**WEST SUSSEX COUNTY COUNCIL
STRATEGIC PLANNING CONSULTATION**

SUBJECT: SY/15/03053/15

Managed breach of shingle spit and blocking of adjacent tidal inlet channel with shingle barrier. Fornation of shingle island within harbour following excavation of adjacent area of spit.

Managed Breach, Pagham Harbour, Rectory Lane, Pagham

Location Plan Showing the Application Area (including access routes)

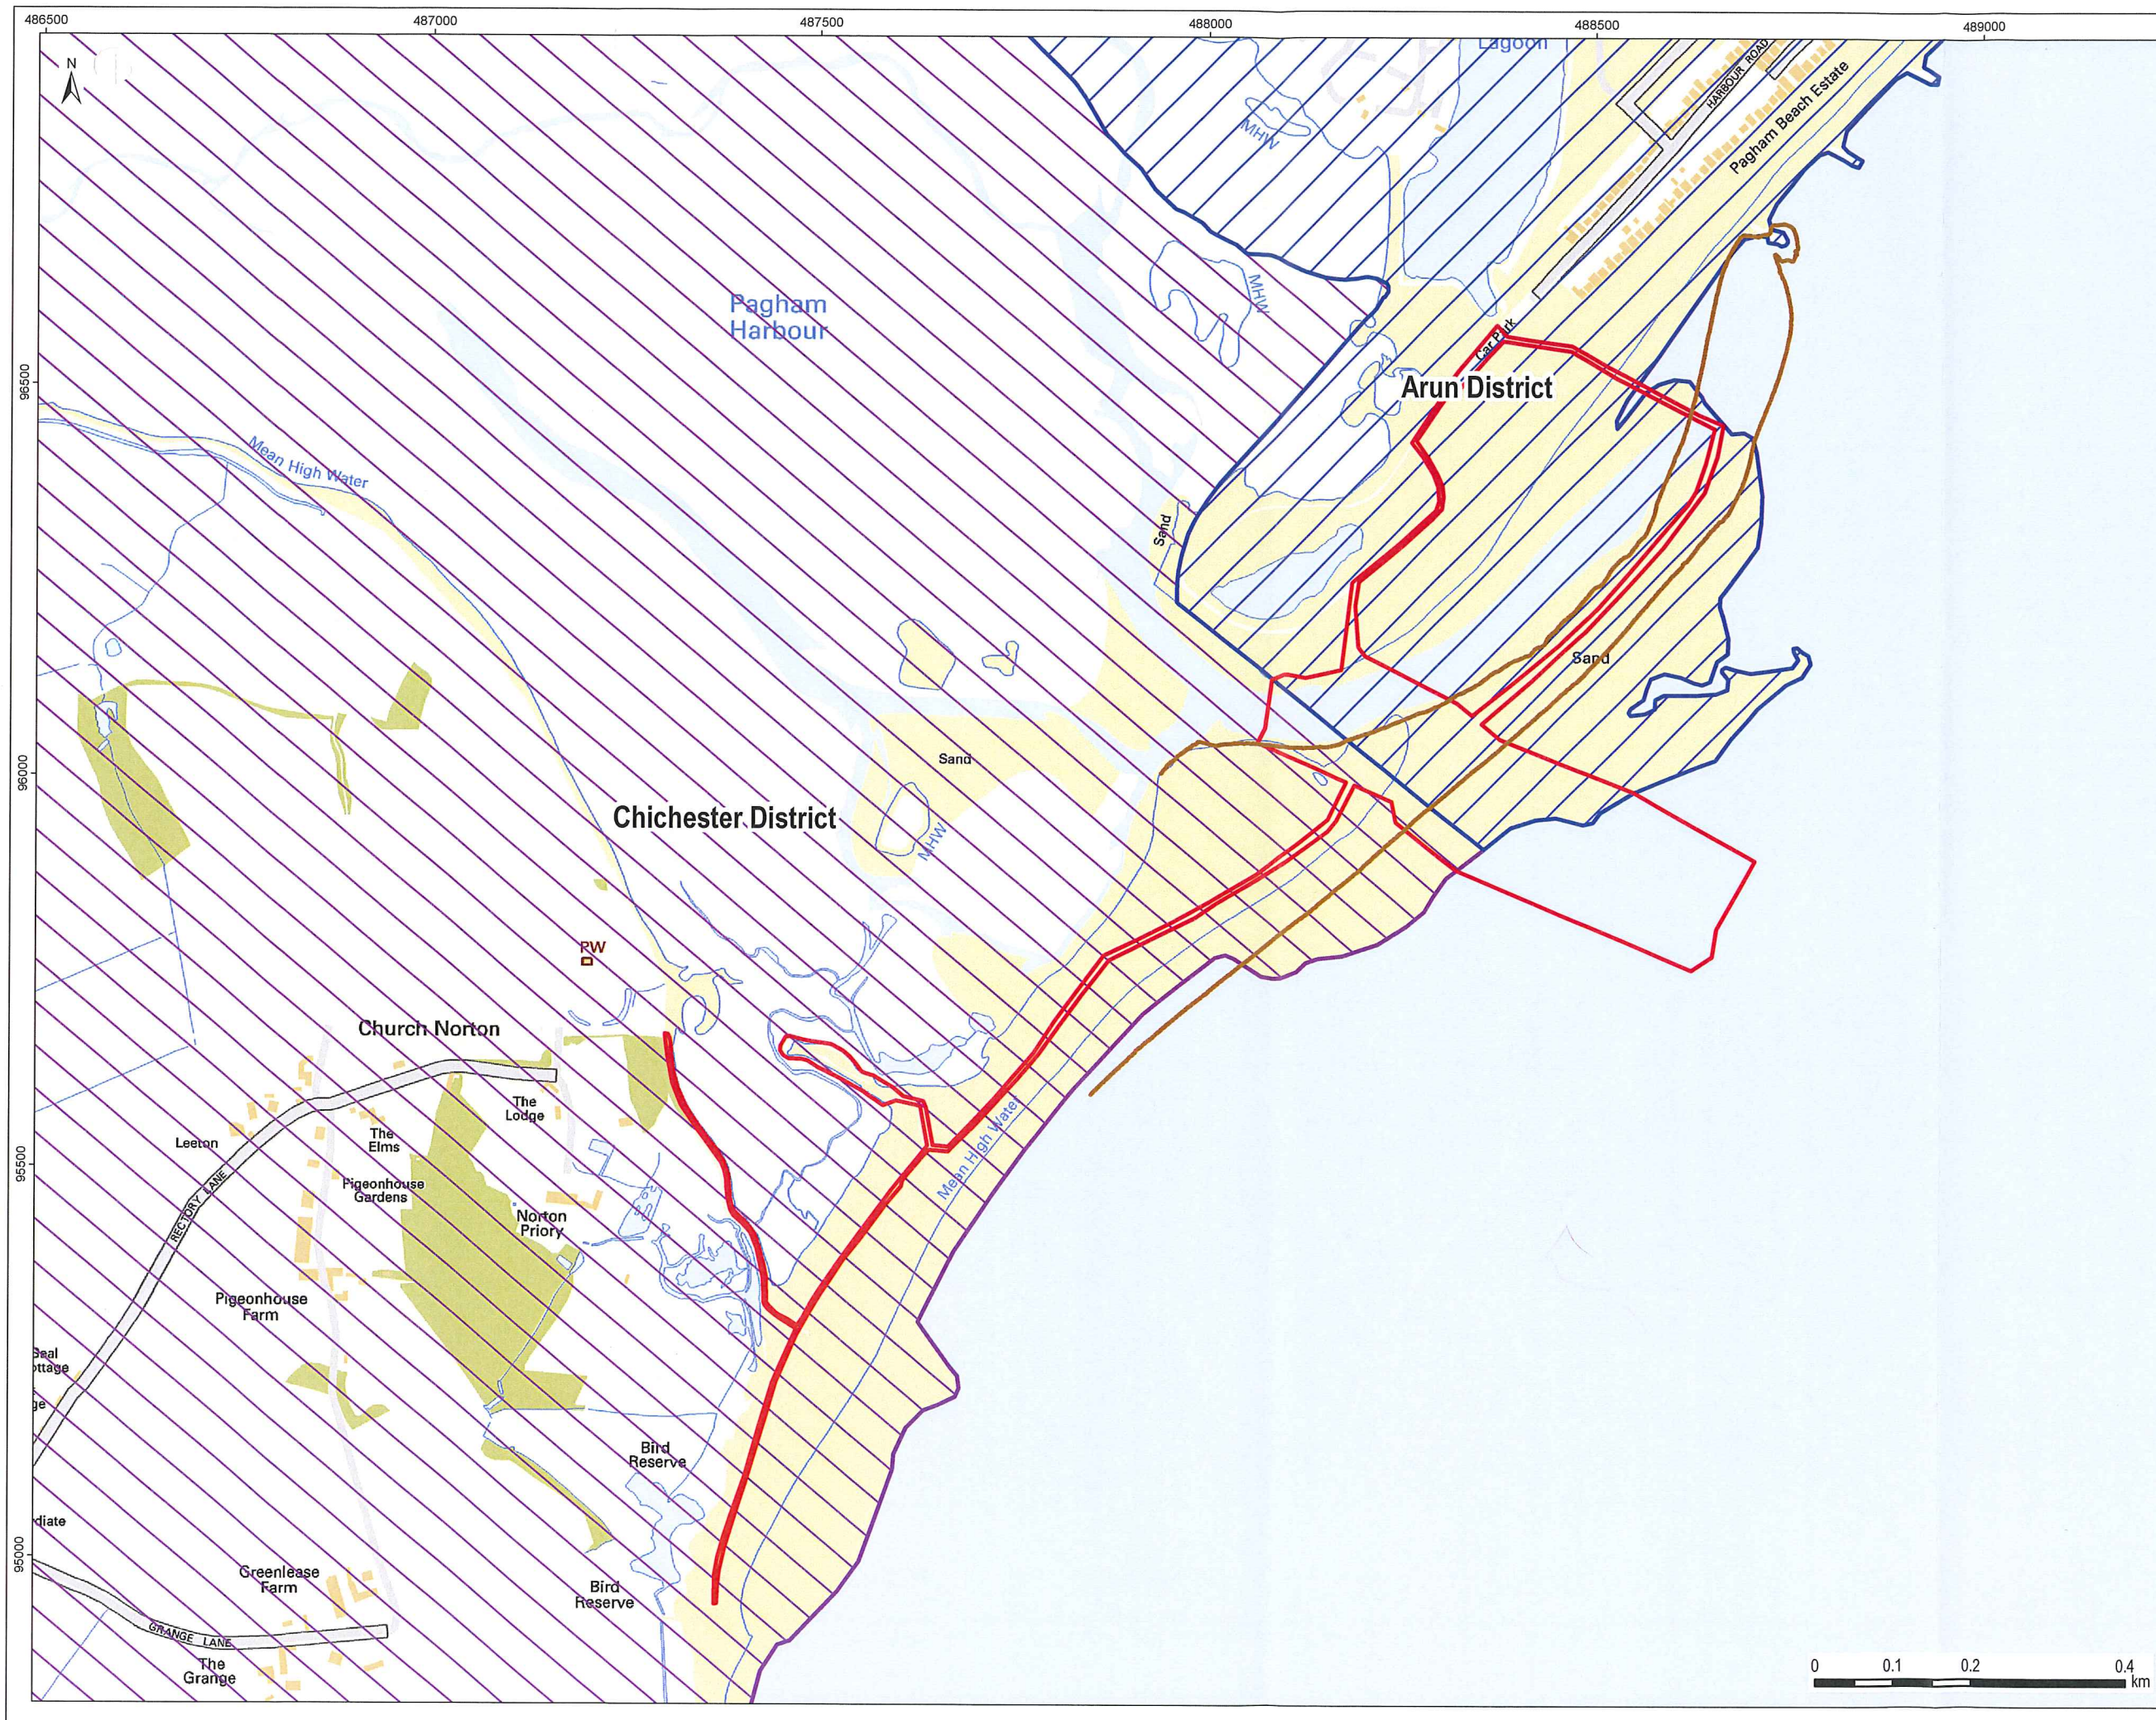
It is understood that the car park at Pagham will be used as a site compound, that both plant and contractors will access the site by road using Rectory Lane and that the works are due to last approximately 9-11 weeks. However, limited information has been provided on how plant will be transported to the site, the frequency and type of vehicles to be used and whether any temporary mitigation will be required to facilitate access.

It is expected that vehicles will travel south along the B2145 before turning onto Rectory Lane. This junction provides access for articulated vehicles entering the Natures Way site which is located in close proximity to the junction. Therefore, movements of HGVs can be accommodated through this junction. However, Rectory Lane itself is a narrow single lane track with limited passing opportunity. Any vehicles, and in particular HGVs, that may meet another vehicle travelling in an opposing direction would not be able to pass one another.

Further information is requested as to how the use of Rectory Lane will be managed through the works period. While the preference of the highway authority would be for this information to be submitted prior to determination, should the planning authority be minded to permit the development, it is recommended that a Management Plan is secured by condition to be resolved prior to commencement. Draft wording is provided below.

No development shall take place, including any works of demolition, until an Access Management Plan has been submitted to and approved in writing by the Local Planning Authority. Thereafter the approved Plan shall be implemented and adhered to throughout the entire works period. The Plan shall provide details as appropriate but not necessarily be restricted to the following matters,

- the anticipated number, frequency and types of vehicles used during construction,

- the method of access and routing of vehicles during construction,
- the use and management of Rectory Lane
- the parking of vehicles by site operatives and visitors,
- the loading and unloading of plant, materials and waste,
- the storage of plant and materials used in construction of the development,
- the erection and maintenance of security hoarding,
- the provision of wheel washing facilities and other works required to mitigate the impact of construction upon the public highway (including the provision of temporary Traffic Regulation Orders),
